Appeal Decision

Appeal Ref: APP/R4408/D/19/3223900

The Ashtrees, Black Moor Farm, Black Moor, Snowden Hill, Barnsley S36 8YR

- The appeal is made under section 78 of the Town and Country Planning Act 1990 against a refusal to grant planning permission.
 - The appeal is made by Mr Scott Wright against the decision of Barnsley Metropolitan Borough Council.
 - The application Ref 2018/1337, dated 19 October 2018, was refused by notice dated 13 February 2019.
 - The development proposed is stone built detached summer house.
-

PROPOSED EXTERNAL  
ELEVATIONS (SHEET 1 of 2)

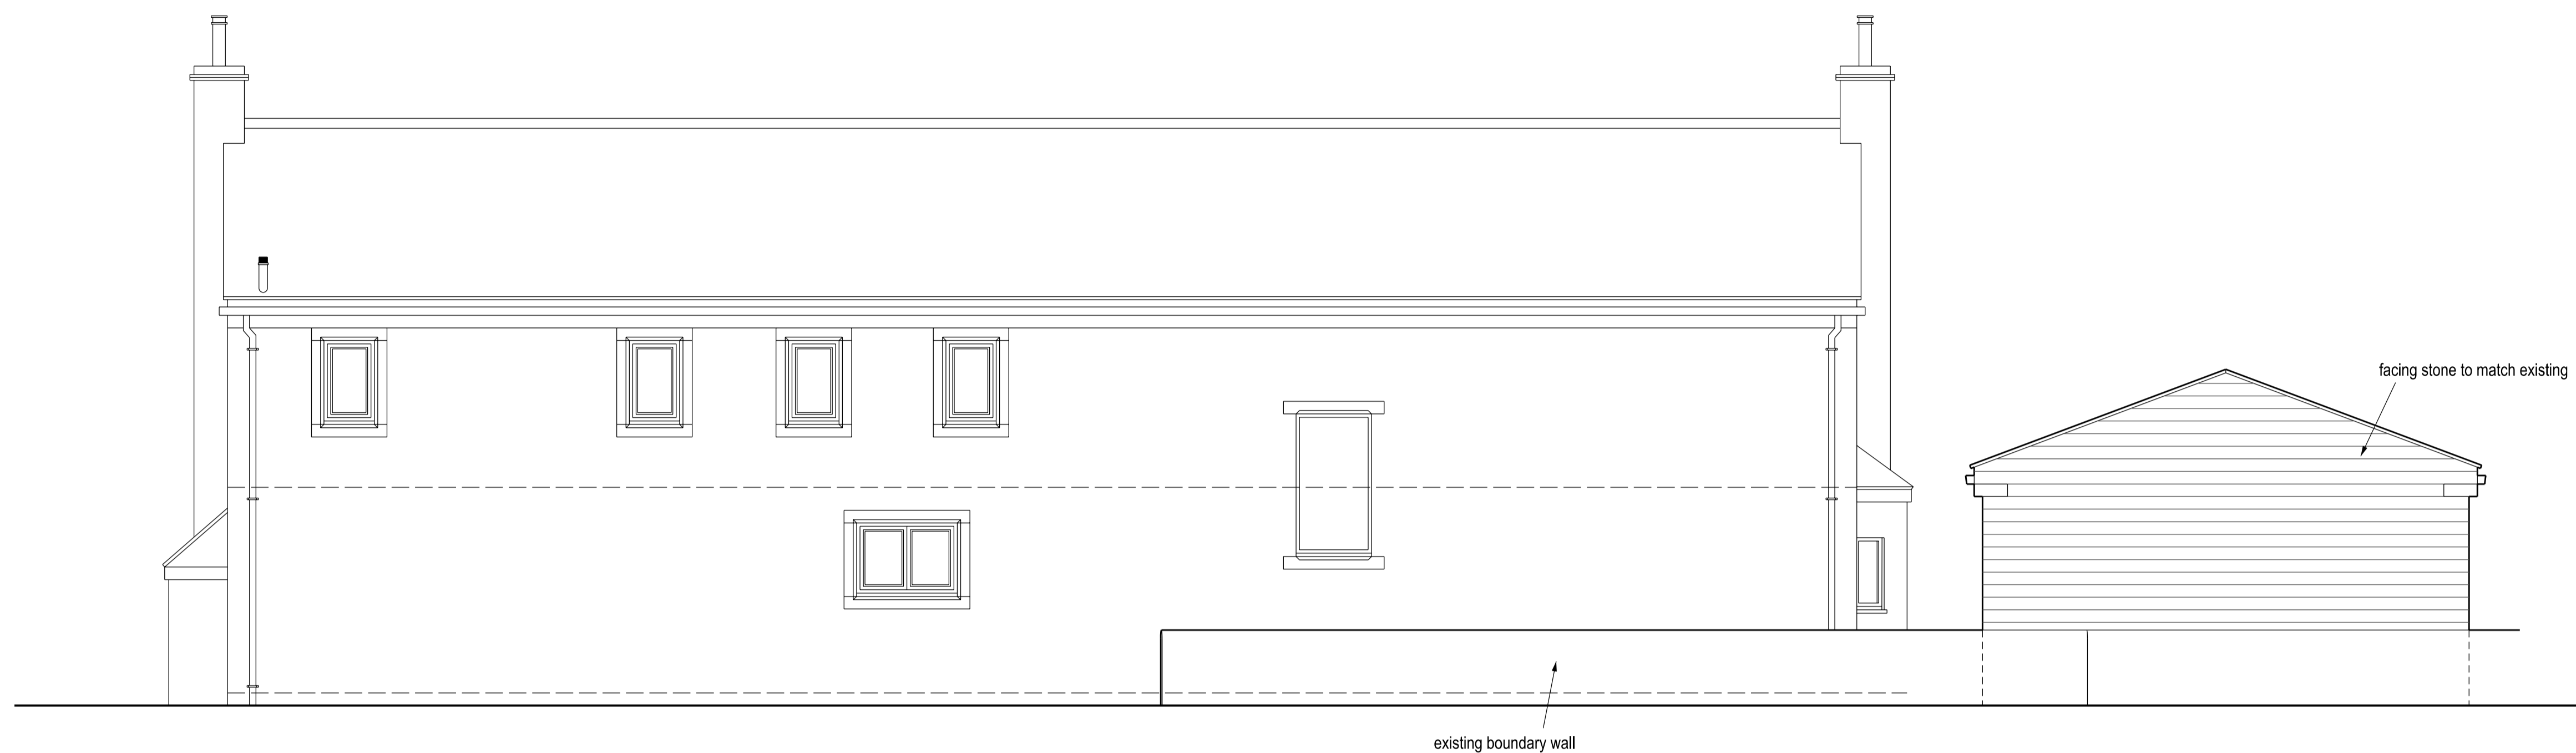
8. The existing property has a strong rectangular emphasis, which is sought to be replicated by the appeal proposal. The summerhouse would be located within 1m of the existing property but would be set at ninety degree to the main dwelling, with a considerable amount of the structure located forward of the front elevation.

9. The substantial dimensions of the appeal proposal would represent a large addition to the host dwelling which would not appear consistent with the architectural layout of that dwelling, sitting forward of the front elevation with a roof design and pitch that would not architecturally complement the existing dwelling. Overall, I find that the design of the appeal proposal would not integrate well with the existing dwelling and not respect its original character.
